TRAILS AT ASPEN RIDGE FILING NO. 2

FINAL GRADING & EROSION CONTROL PLANS

NOVEMBER, 2019

DESIGNED BY:	NMS	SCALE:	DATE ISSUED:	NOVEMBER 2019	DRAWING No.:
DRAWN BY:	CRD	HORIZ:	1"=50'		
CHECKED BY:	NMS	VERT:	N/A	SHEET	4 OF 8
FOR AND ON BEHALF OF MATRIX DESIGN GROUP, INC. PROJECT No. 19.886.014					GC01

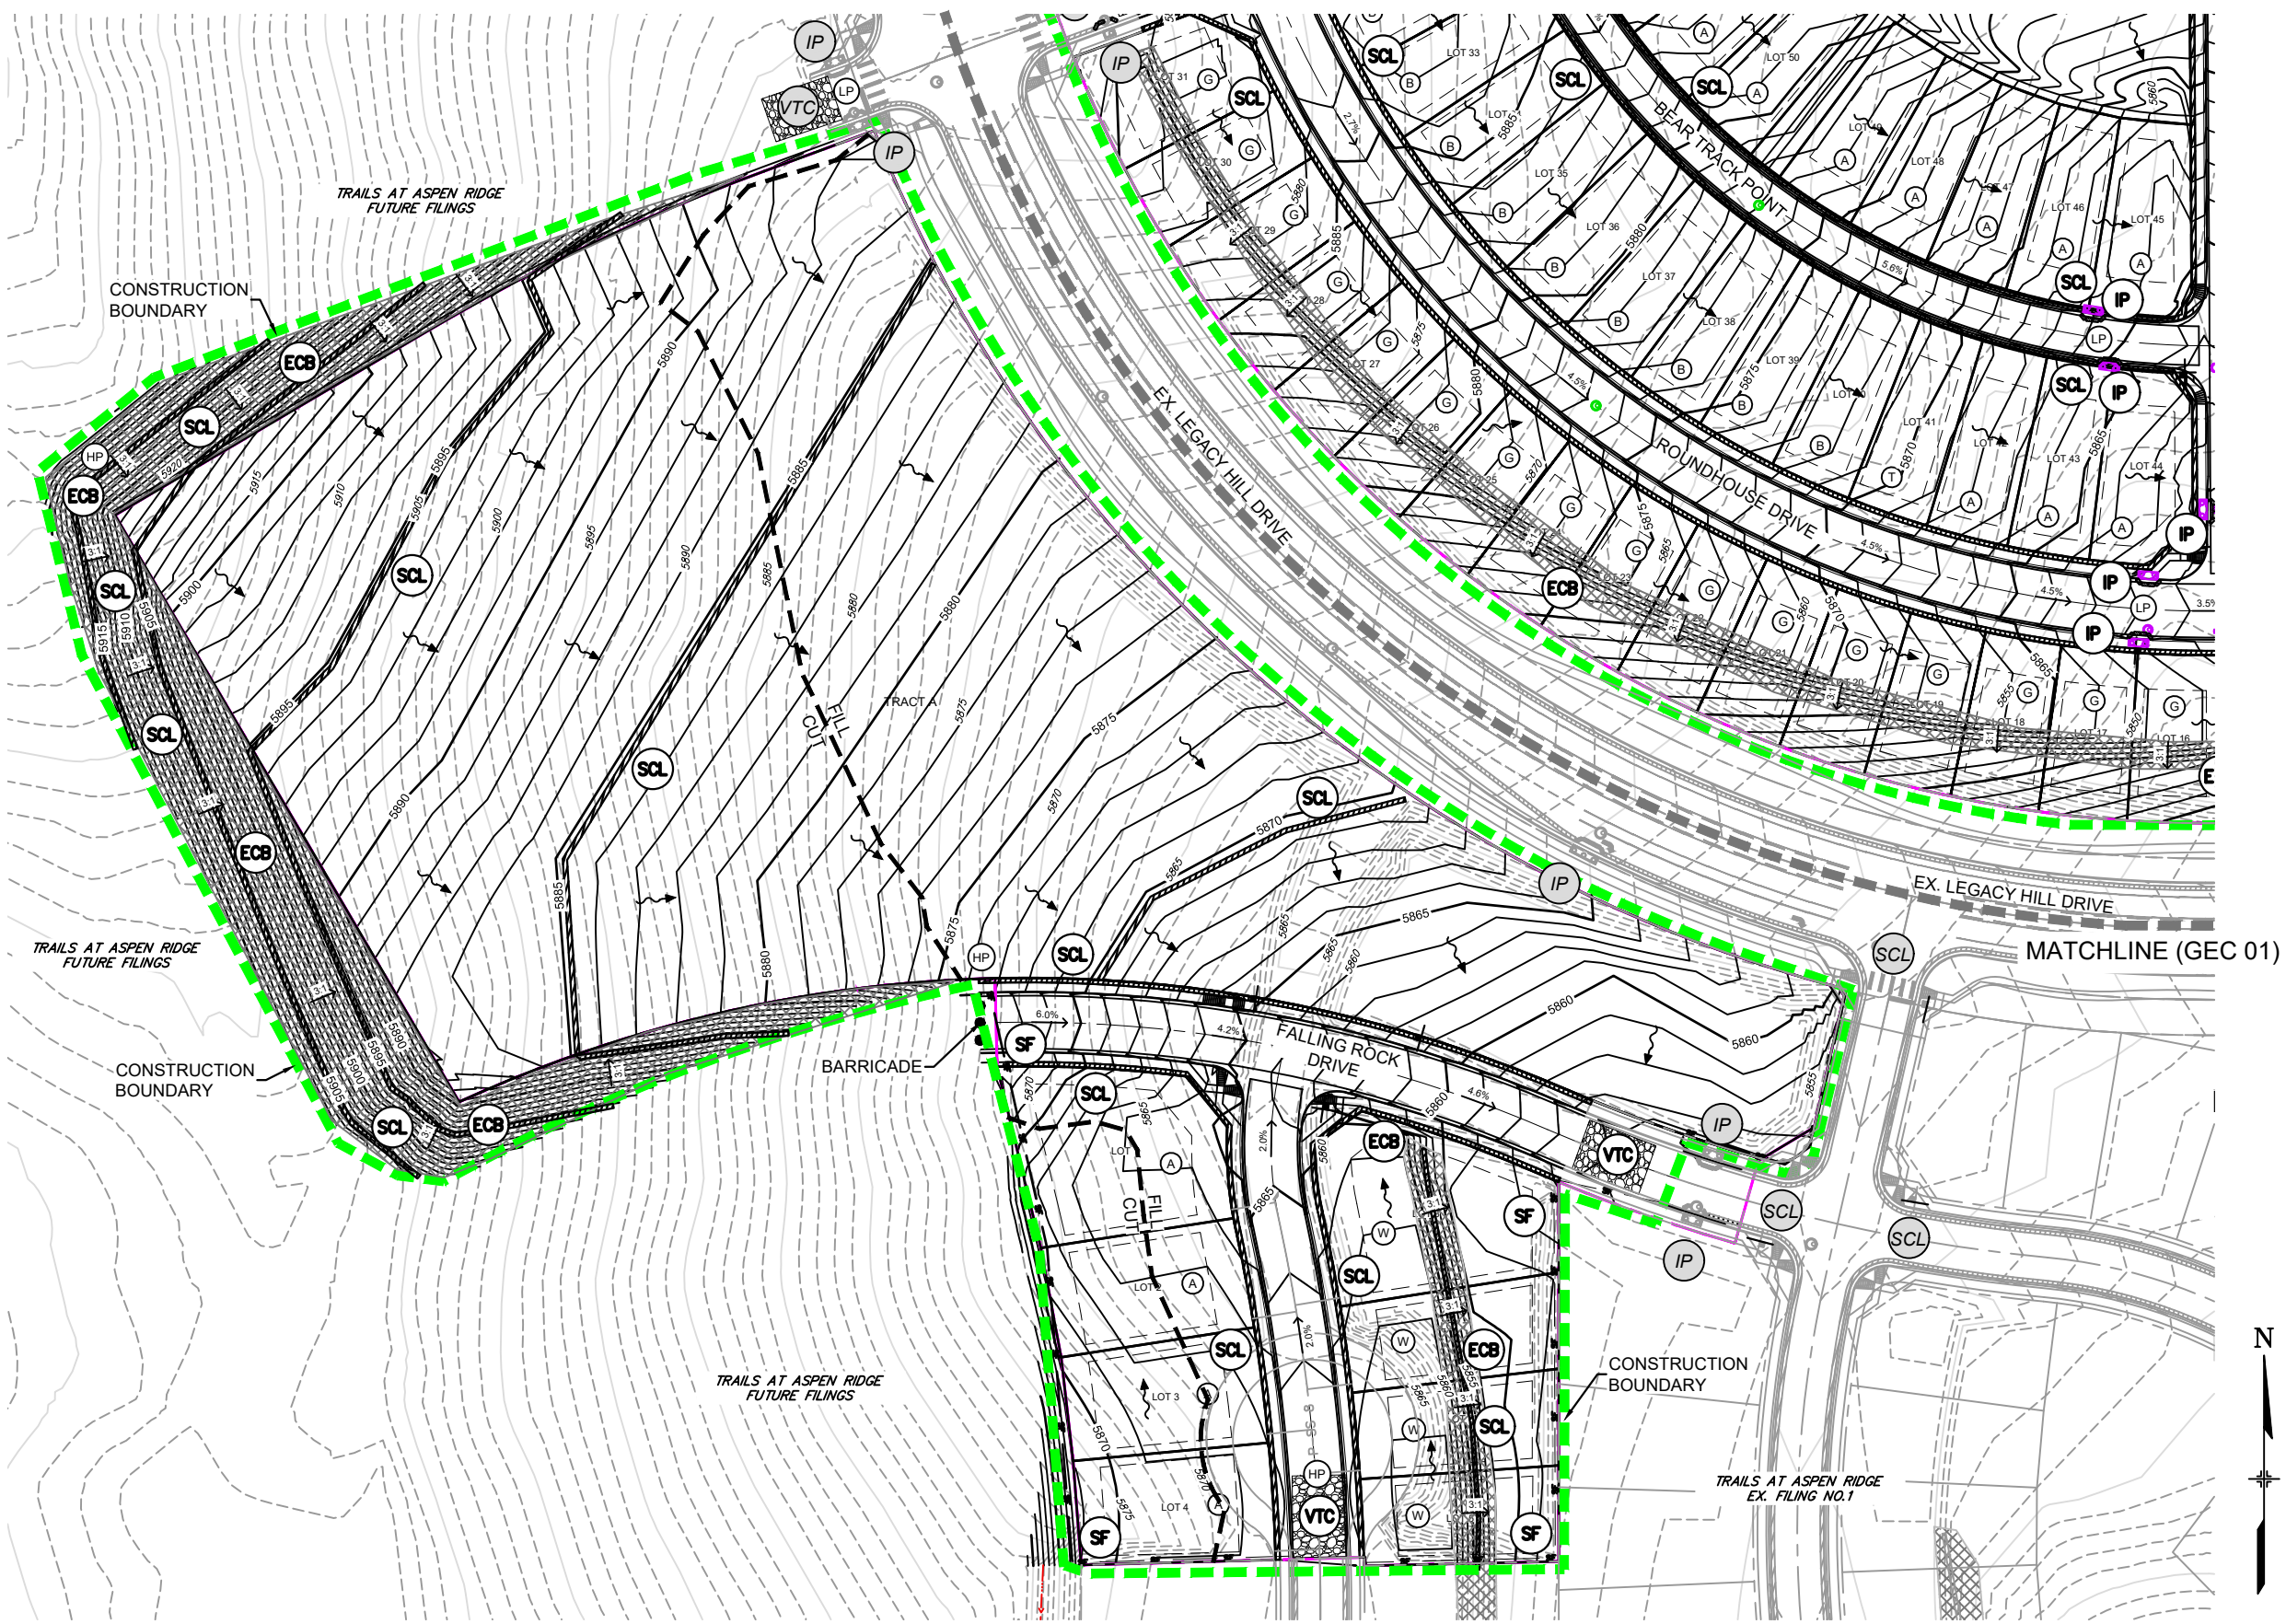
Remove. No inlet shown on north side of Moose Meadow.

Superelevation is not permitted for design speeds less than 50 mph. Revise or submit a deviation request.

Label max height or provide spot elevations along the retaining walls

Fix contour so it doesn't show berm along the property line.

Please add these stormflow arrows to the legend.

Show the proposed and existing stormdrain lines.

Provide erosion control along the ROW line.

Adjust ECB hatch boundary so it's not overlapping the sidewalk.
